ST ANTHONY OF PADUA SSD -8865 - RESPONSE TO REQUESTS FOR FURTHER INFORMATION

This letter supports the Response to Submissions report (RTS) provided to you on 18 November 2019 in respect of SSDA_8865 for the proposed St Anthony of Padua Catholic School (the Proposal) at 125-165 Tenth Avenue and 140-170 Eleventh Avenue, Austral (the site).

This letter has been prepared on behalf of SCS in response to NSW Department of Planning, Industry and Environment's (DPIE) request for additional information of 9 December 2019 and further request of 29 January 2020.

1 DIAGRAM - STAGING 3
1 : 1000

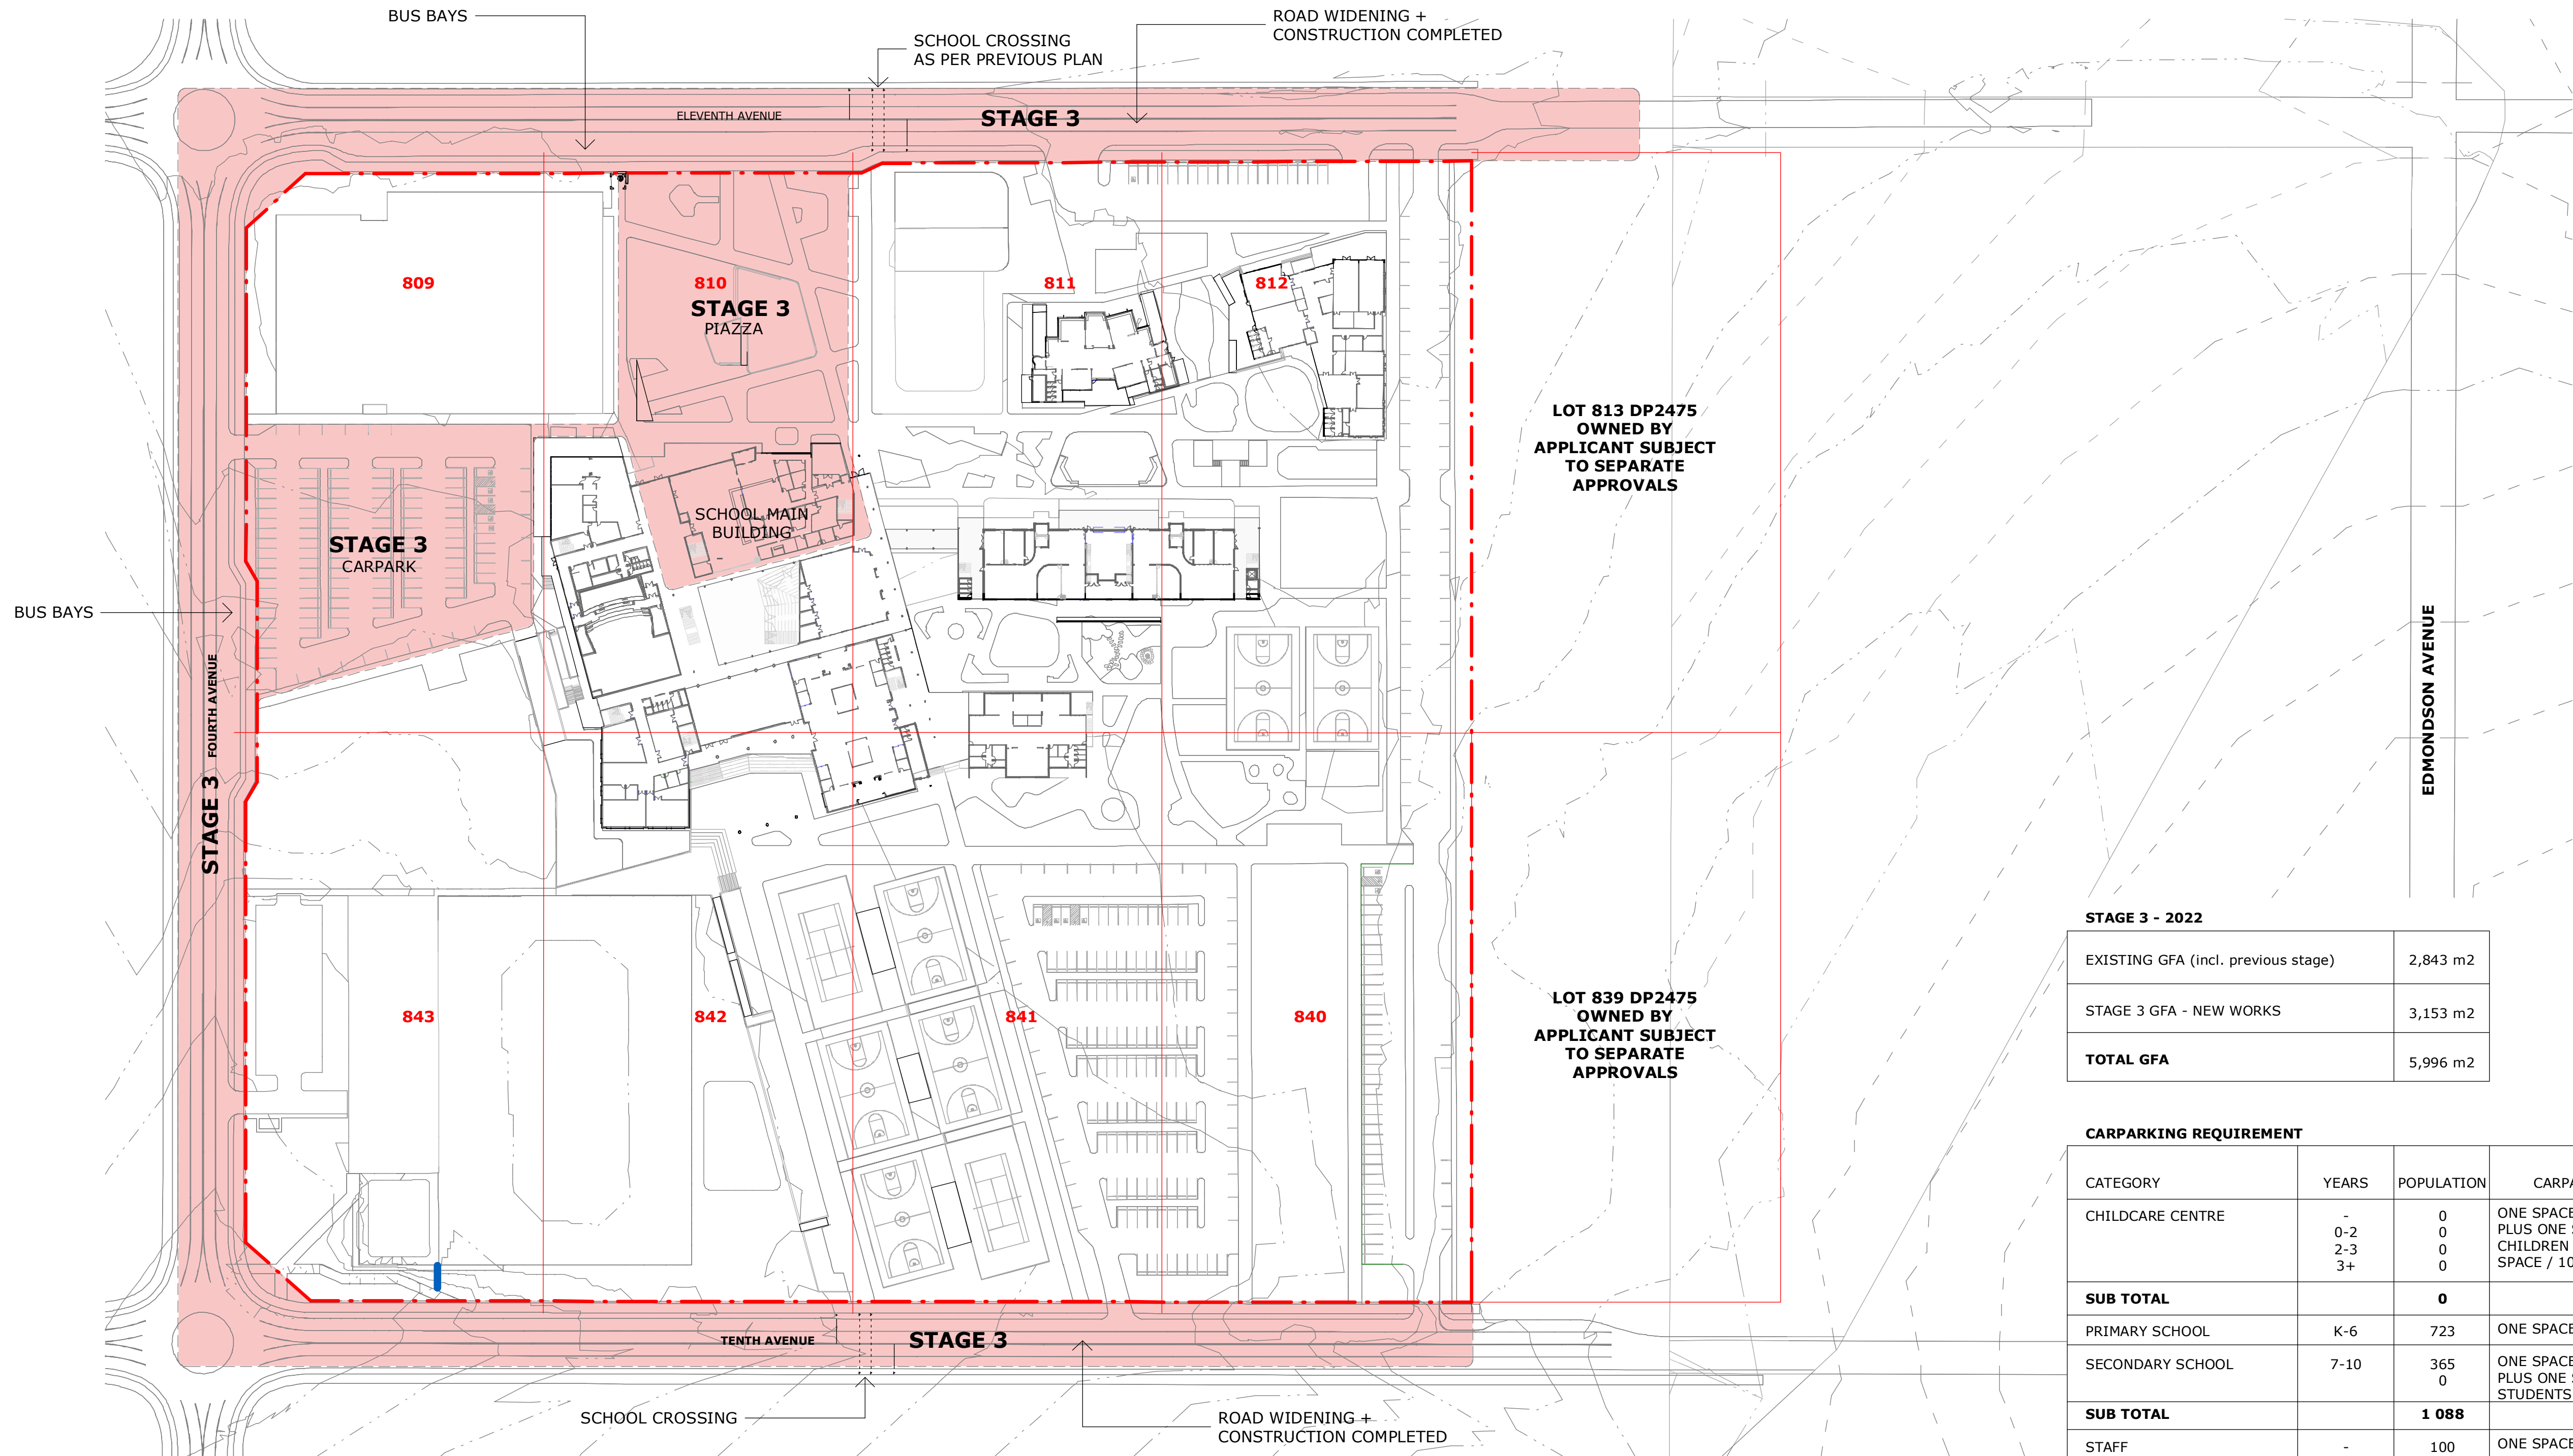
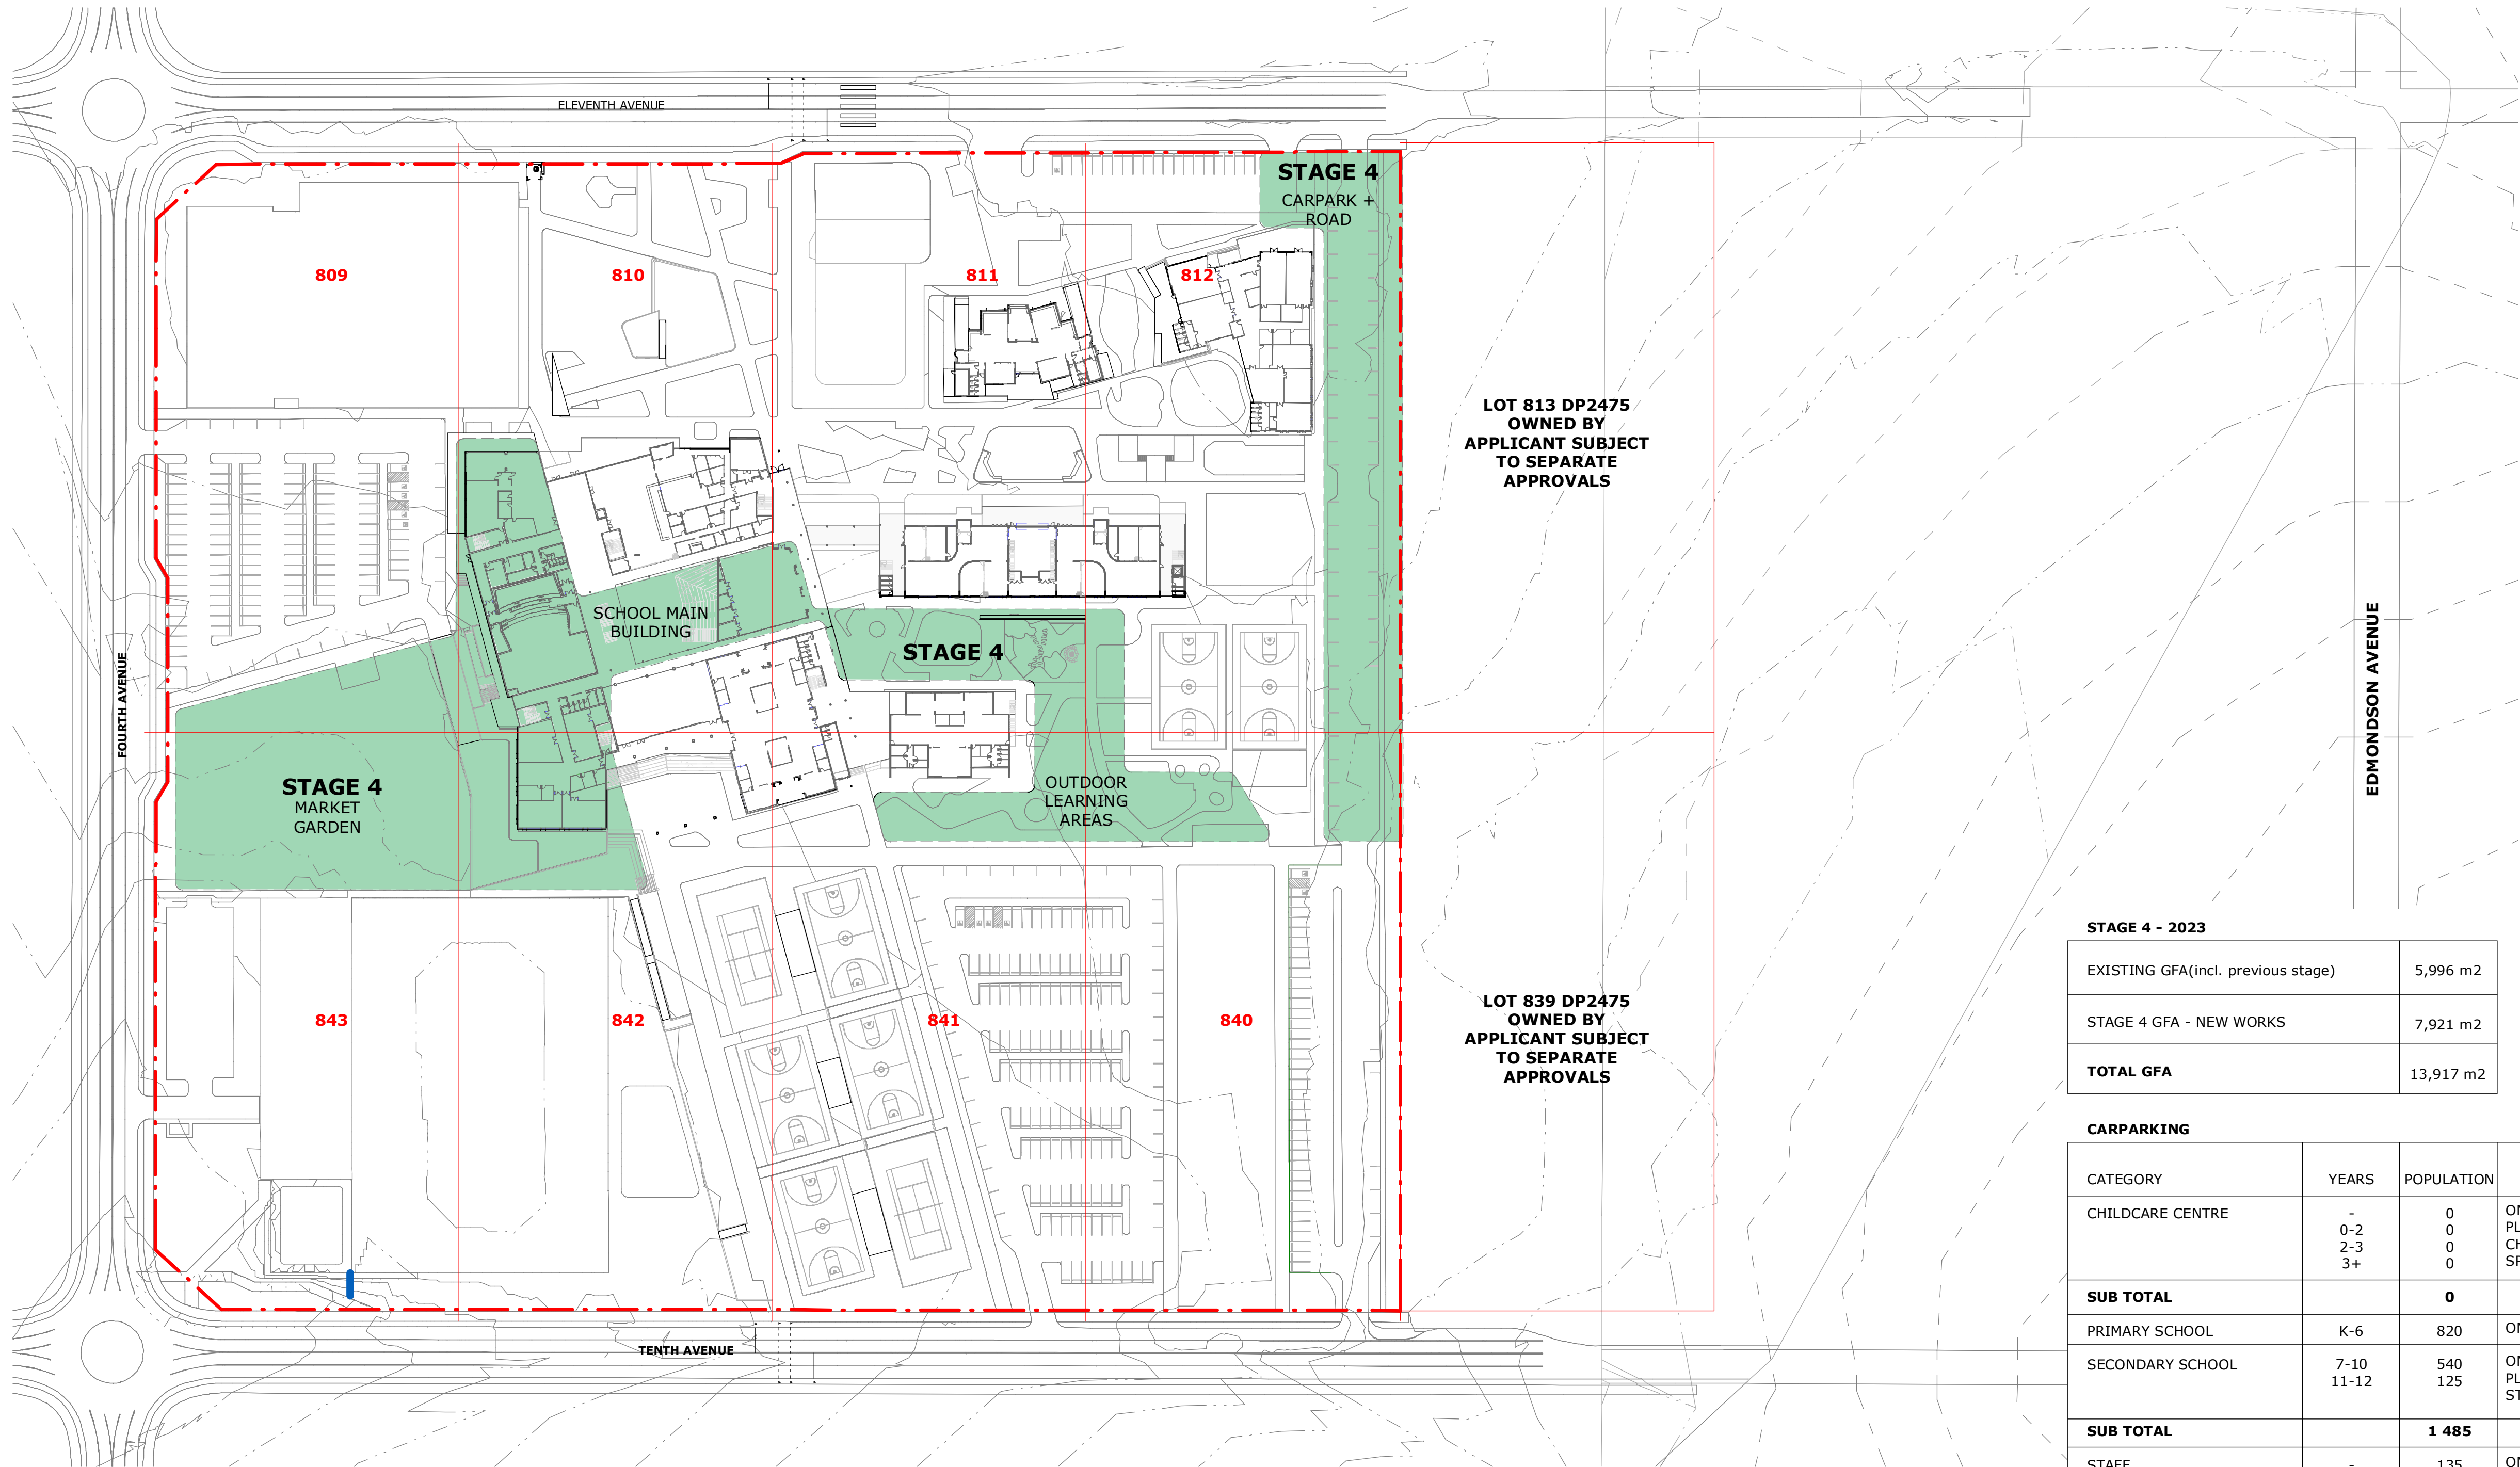
<p>4.4 In addition to student and staff numbers for each stage, the following information are also required for each construction stage:</p> <ul style="list-style-type: none"> the number of drop-off and pick-up spaces, bike parking spaces for each stage and whether the numbers are adequate to cater for the number of 	<p>Amended staging plans have been prepared which provide this information- refer DA052-DA059.</p>	<p>Attachment A- Architectural Plans – refer DA052-DA059 inclusive.</p>

Matter	Response	Refer to
<p>students.</p> <ul style="list-style-type: none"> the gross-floor area for each construction stage. The correct number of car parking and drop-off and pick-up spaces for construction Stage 4 noting that the existing information is incorrect (177 car spaces) as it does not include the proposed 22 drop-off and pick-up spaces. 	<p>Overall site GFA plans have been provided at DA131_R10 and DA132_R10. GFA per stage has also been quantified on the amended staging drawings, refer DA052-DA059.</p> <p>The number of car spaces inclusive of drop/off pick up spaces for Stage 4 is 227 and this has been corrected on DA055_R7.</p>	<p>Attachment A-Architectural Plans – refer DA131_R10 and DA132_R10.</p> <p>Attachment A-Architectural Plans – refer DA055_R7.</p>
5 Road widening		
<p>5.1 The RtS indicates that the proposed development includes road widening of Tenth Avenue, Eleventh Avenue and Fourth Avenue. While Eleventh Avenue is proposed to be fully widened, the civil plans show that Tenth Avenue and Fourth Avenue would only be widened for half of the width. The RtS does not clarify whether the remaining section would be widened as part of this proposal or at a later date. It also does not include reasons for not proposing the road widening for the full width of the road.</p>	<p>The proposal is for the widening of Tenth Avenue and Fourth Avenue along the site frontage. The proponent does not intend to widen the roads beyond the site frontage at any point in the future.</p> <p>The proposal also does not propose to widen the southern side of Tenth Avenue or the western side of Fourth Avenue at this time or at any point in the future. It is unreasonable for the proponent to be made to bear the cost of widening the roads beyond the boundary of the school site or for the cost of widening both sides of Tenth and Fourth Avenue.</p> <p>The proposal to widen the road as shown in the accompanying civil plans is satisfactory to accommodate 4 lanes of traffic</p>
